Mandy Richardson
Clerk and RFO
Barrow Parish Council
14 Black Lane Croft
Clitheroe
BB7 2EZ

Barrow Parish Council Response – Planning Applicatino 3/2021/0397 Land at Barrow Brook Enterprise Park Barrow BB7 9QZ

DRAWING TITLE:
Proposed Site Plan

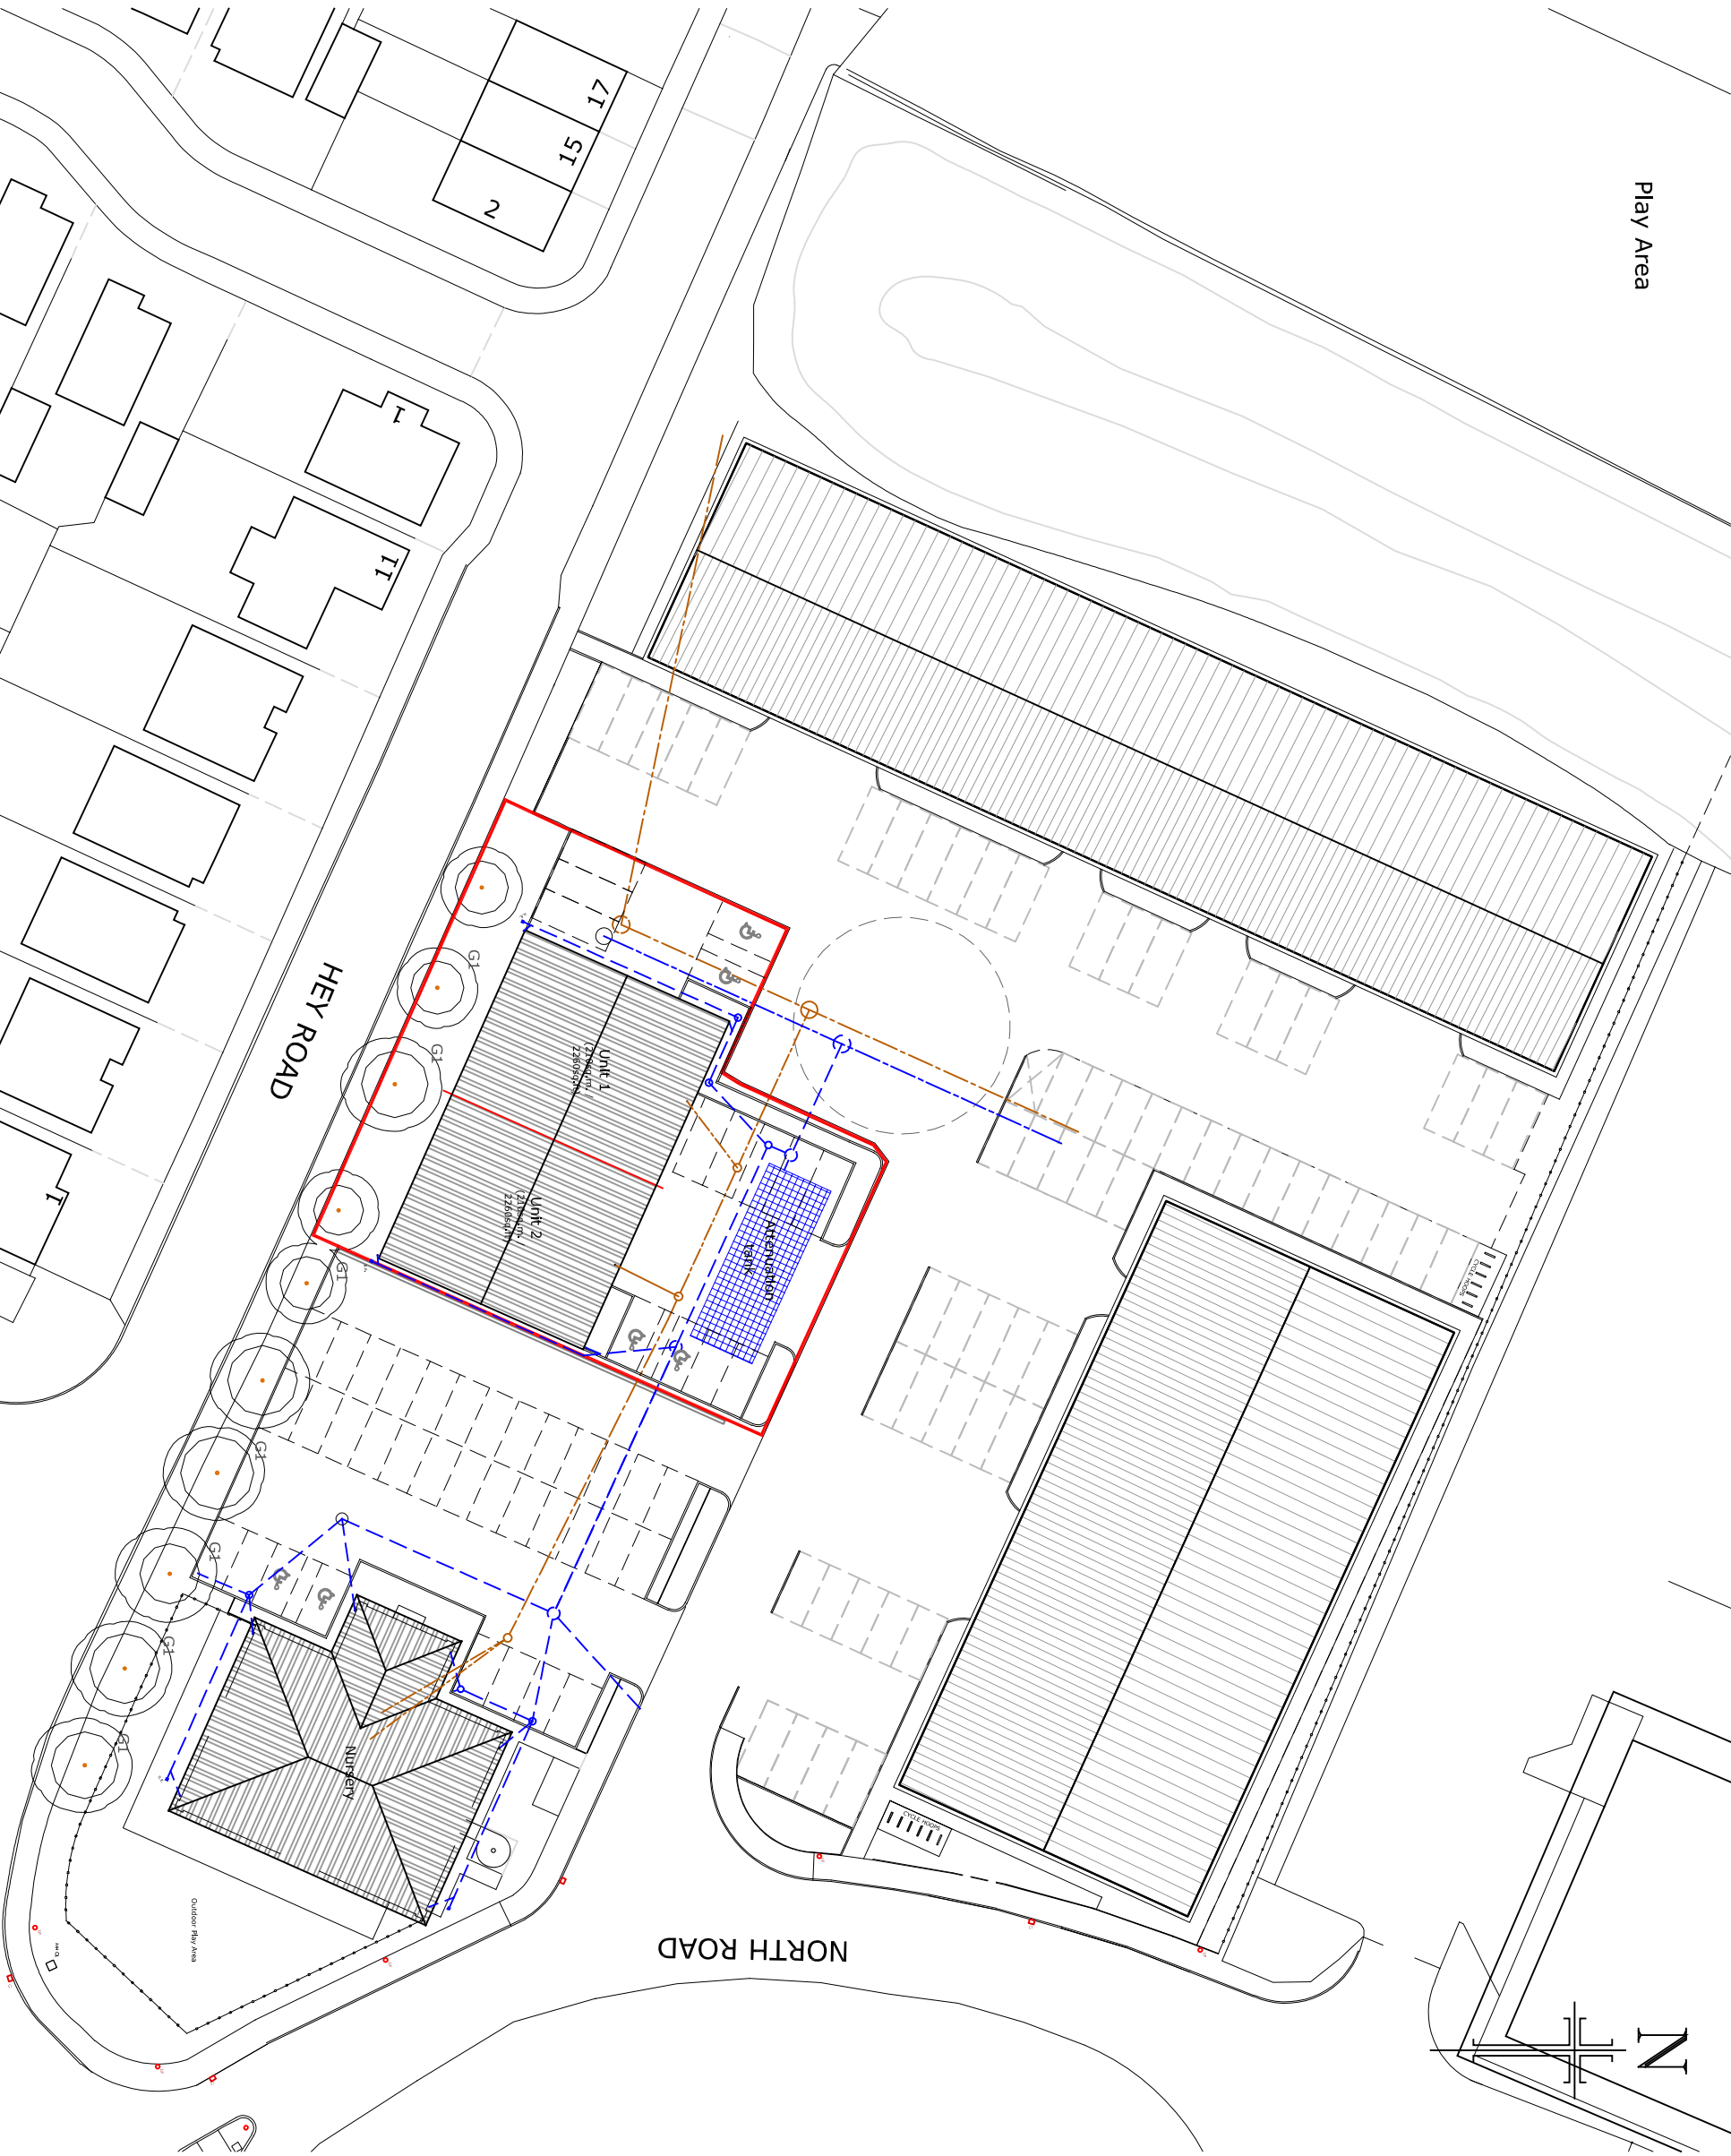
The proposed site plan states - units 1 & 2 & not 11 & 10.

Parking is an issue that is not made clear on the drawings. The current parking bays for unit 9 are not shown on the various drawings, are these also to be used/ be part of parking for customers of unit 11?

Unit 11 is shown before unit 10 on the plans, if this a mistake, should the numbers not be in numerical order?
